From: Ian Stocks [redacted] **On Behalf Of** FRS Water and Access
Sent: 01 April 2022 10:55
To: Simon Davis <Simon.Davis@arun.gov.uk>
Subject: RE: Planning Consultation on: AL/36/22/DOC

Application No: AL/36/22/DOC

Site Address: Land At Wings Nursery Lidsey Road Woodgate PO20 3SU

Description of Works: Approval of details reserved by condition imposed under AL/20/21/PL relating to condition 22-details of required fire hydrants.

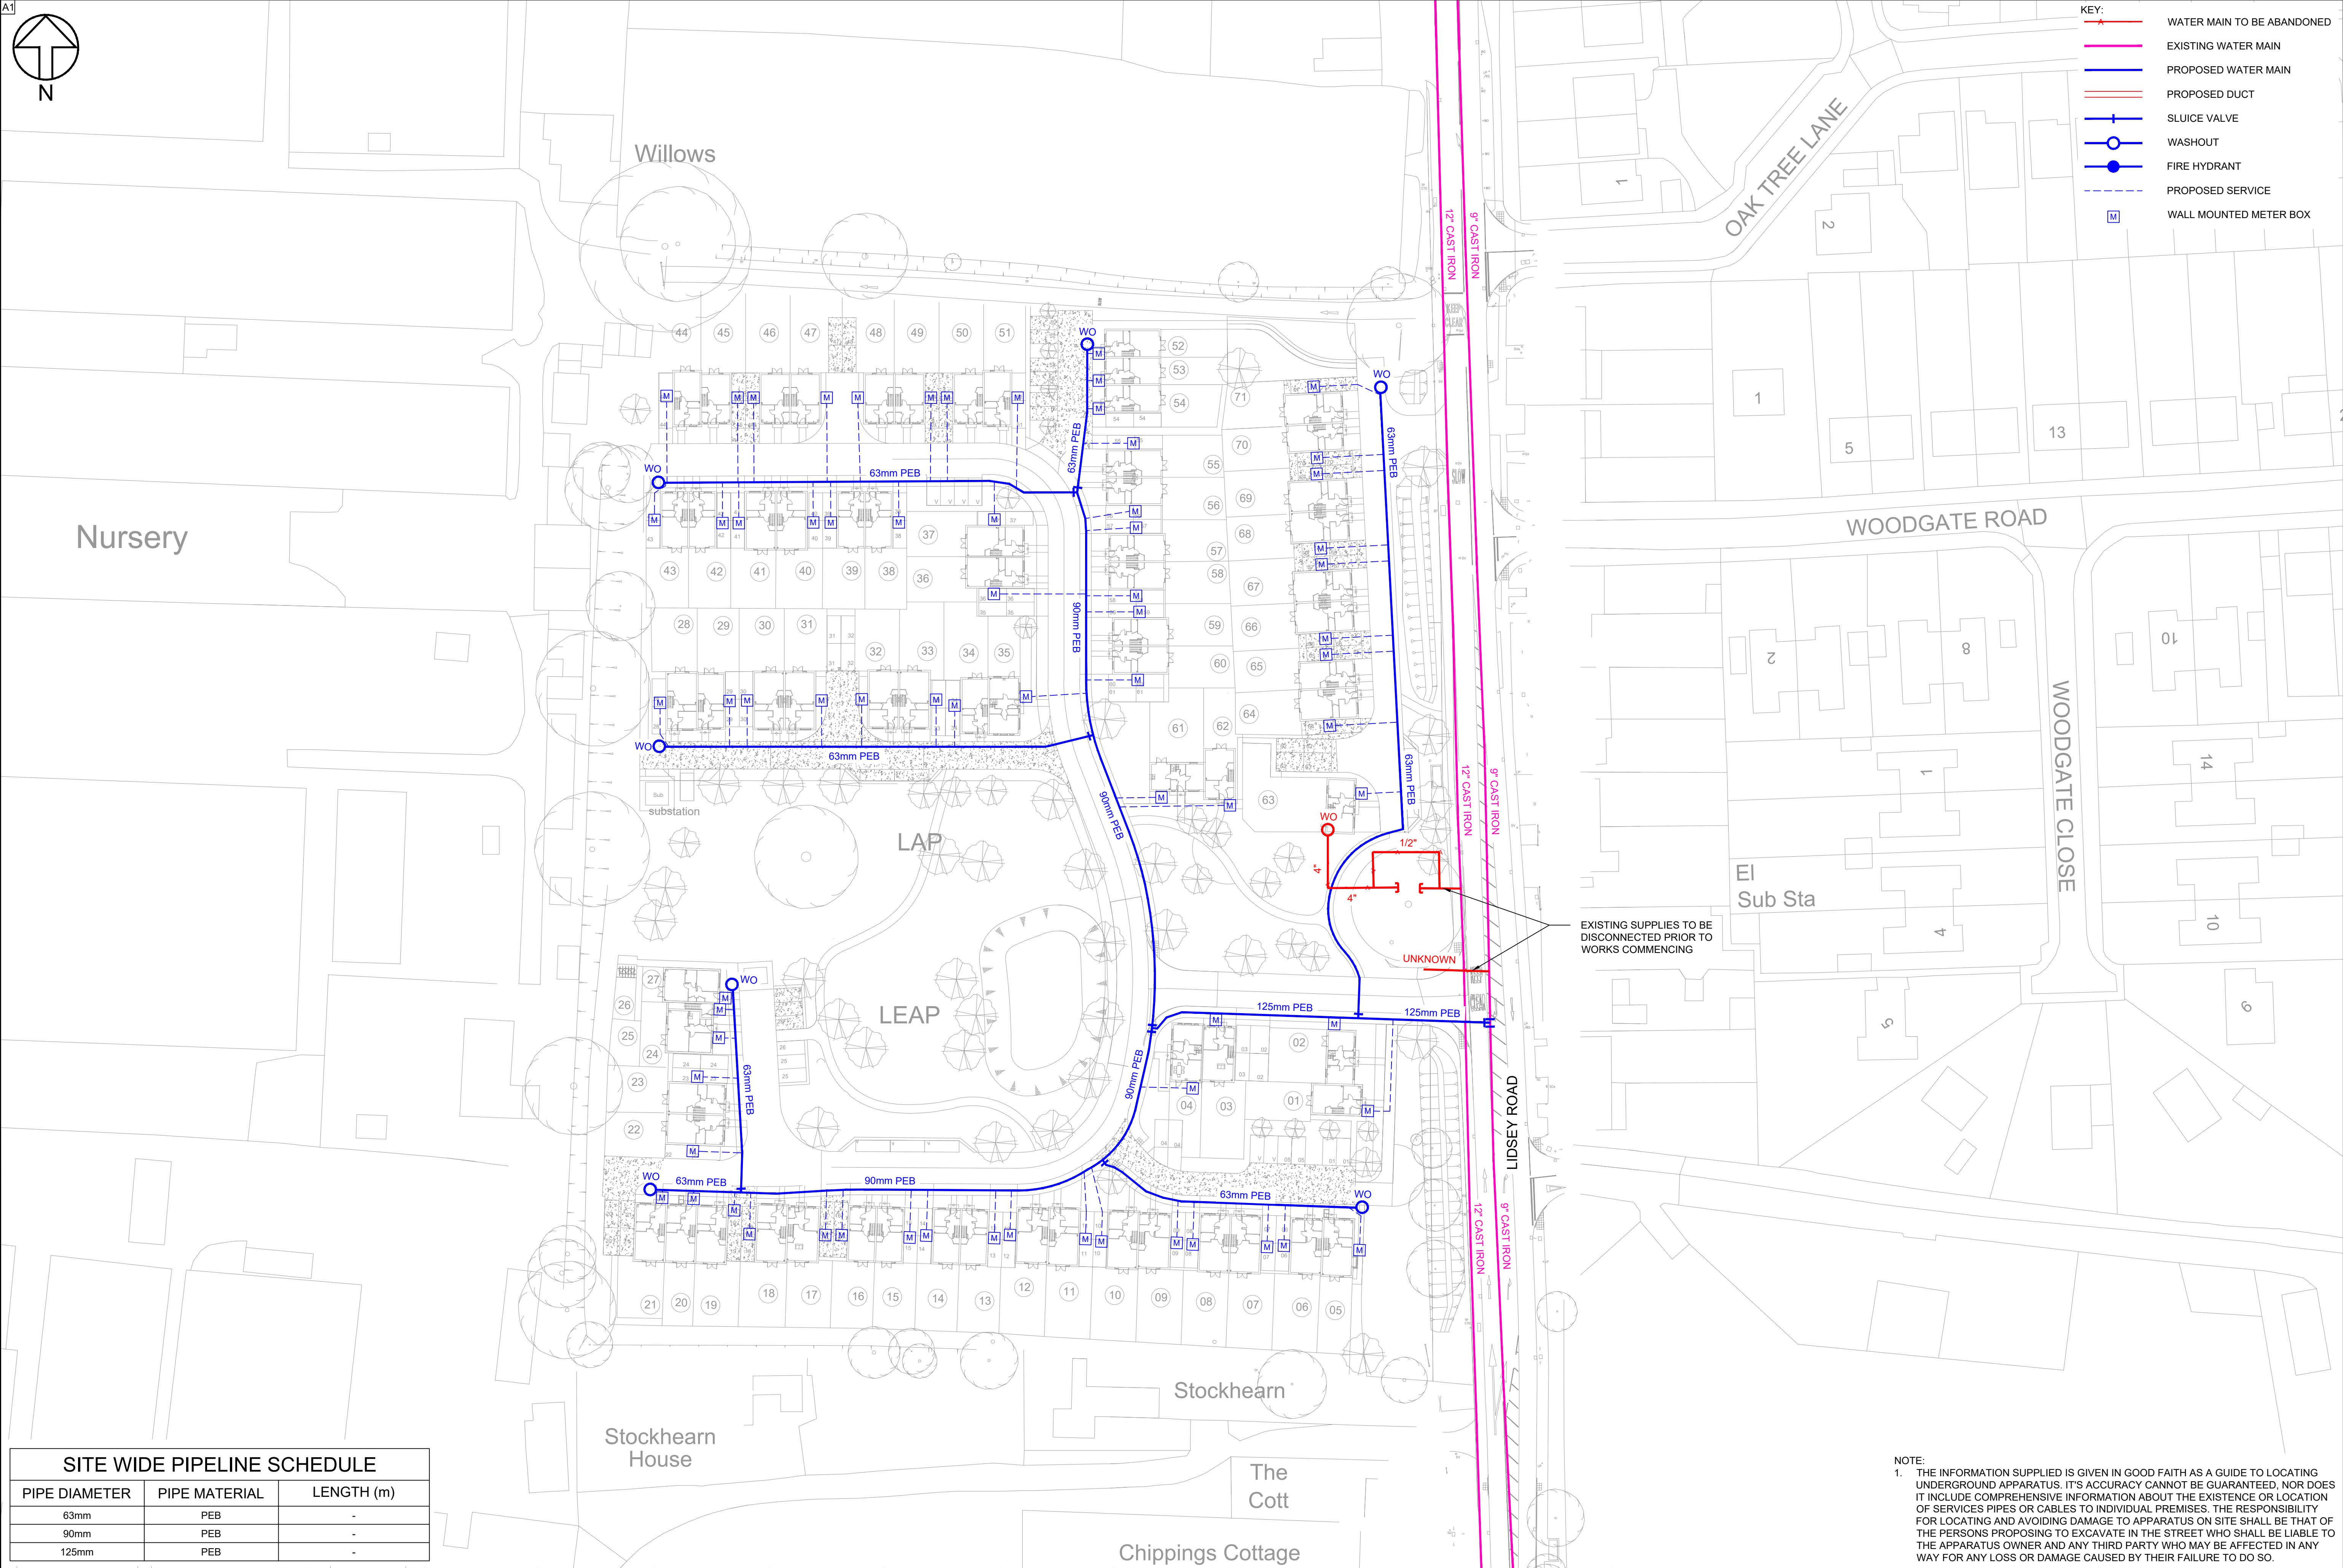
The water main plan submitted does not have any fire hydrant locations indicated and all the wash out hydrants are on 63mm mains. The minimum mains size for a fire hydrant is 90mm, so the mains indicated on the plan is not suitable for supplying any fire hydrants, the mains size is too small.

This was consulted on with the Water Supply and four fire hydrants were required.

Therefore the fire hydrant condition has not been met and should not be discharged.
